CITY OF ALBUQUERQUE

March 26, 2013

**Re: L&C Transport Private Metal Garage, 8705 Central Ave NW,
Traffic Circulation Layout, Engineer's Stamp dated 03-11-13 (K9-D037)**

TRAFFIC CIRCULATION LAYOUT

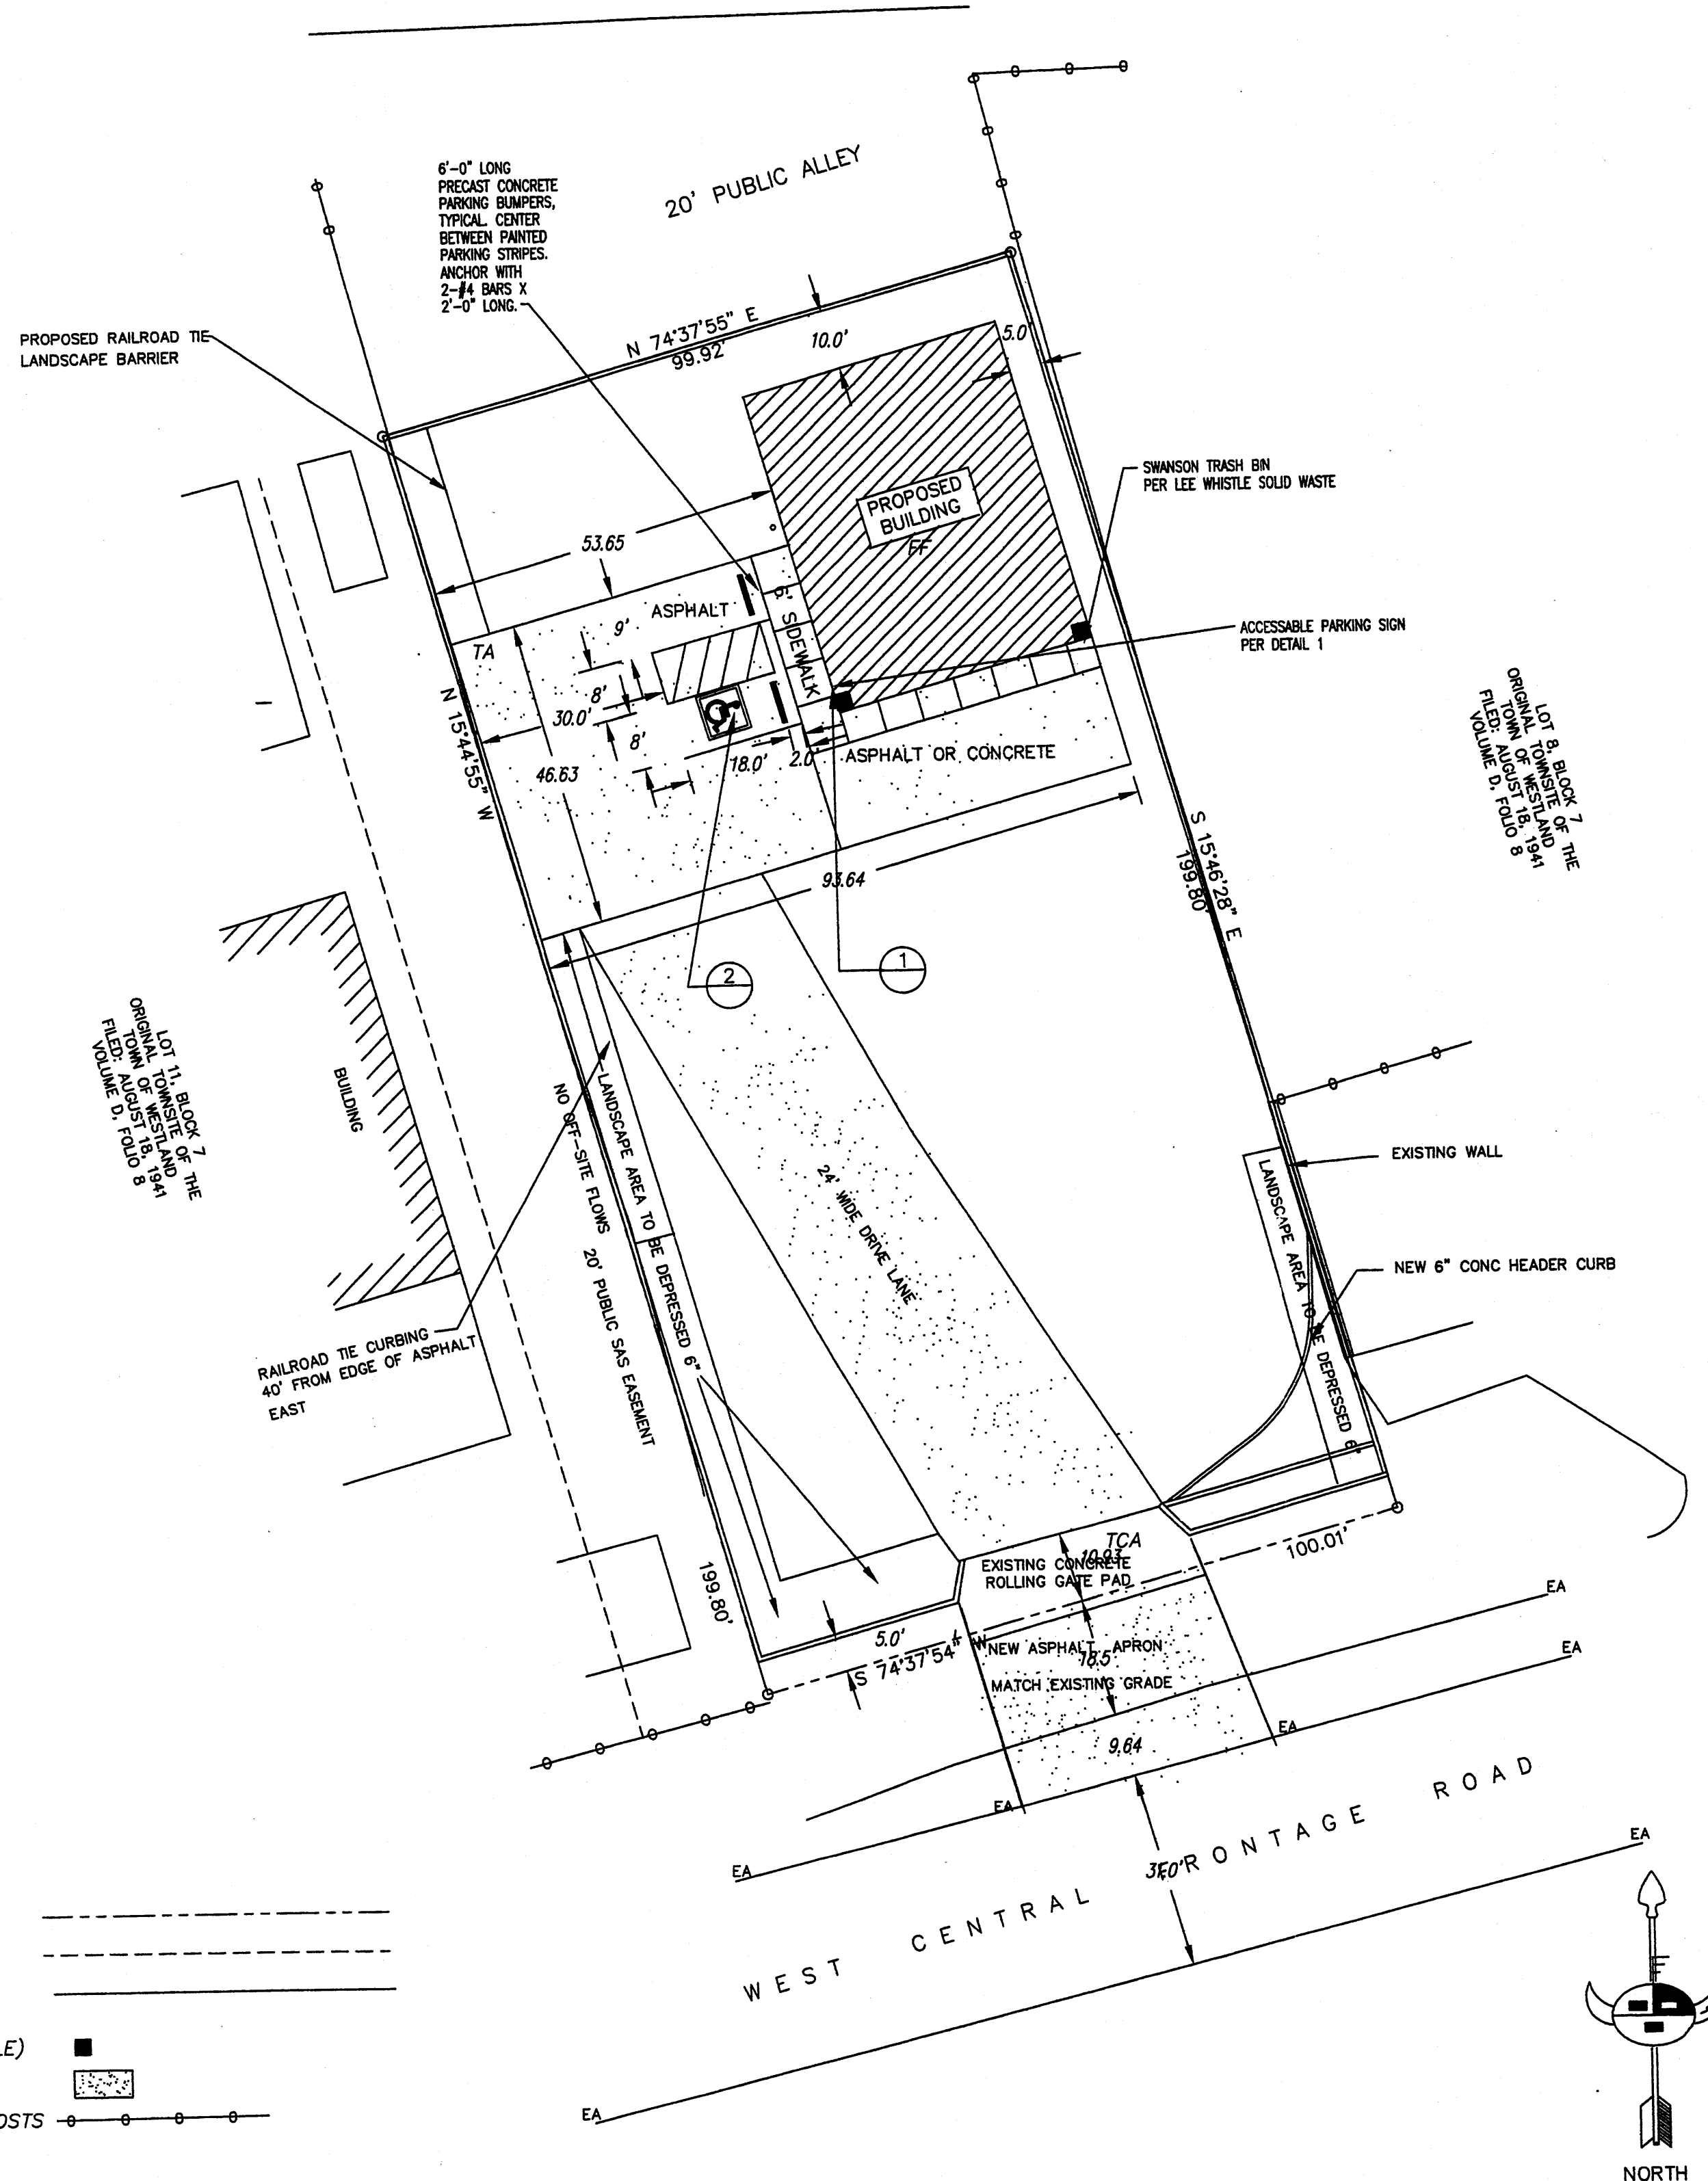
1. List the number of parking spaces required by the zoning code as well as the proposed number of parking spaces.
2. According to C.O.A. program AGIS, the site to be developed is 2 lots. Is this site going to be re-platted into one lot? If not, shared access agreements between lots must be provided.

3. Please clearly define and label all lot lines, property lines and existing easements.
4. Please define, dimension, and label all proposed infrastructure to be built on private and public property (including tire stop at parking stalls, posted sign at handicap stalls, radius of curbs, width of all drive aisles, hard surface paving material of all drive aisles, depth of proposed drive pad, existing and proposed sidewalk widths).

5. Is the sidewalk abutting proposed building raised or flush with parking area? If raised, an ADA accessible ramp from the HC stall access aisle must be provided, please include design details.

6. Is landscaping required by zoning? If so, please provide landscaping plan with next submittal. Per the *Development Process Manual*, Chapter 23, Section 7, Part B.6, curbing should be used to separate landscaping from parking areas and pedestrian ways as well as providing a physical perimeter for harvesting water. This must be clearly shown on the TCL.

7. The plans indicate a new drive pad will be built over a portion of the existing dirt lot frontage. According to DMP standards, the drive pad must be constructed of Portland concrete cement per COA standard drawing #2425 or provide design details.

8. Sidewalk is required along the Central Frontage Rd. property limits, unless a variance is requested by the Planning Department's Traffic Engineer.

9. It is not apparent what type of pavement surface is being proposed. A hard driving surface will be required as part of this proposed project for parking area and drive aisles. A minimum 24 foot drive aisle must be provided that begins at the edge of the existing pavement to the parking area.
10. Please clearly differentiate and define all line-types applied in the TCL.
11. The development of this site must be in compliance with current DPM and ADA standards and regulations.
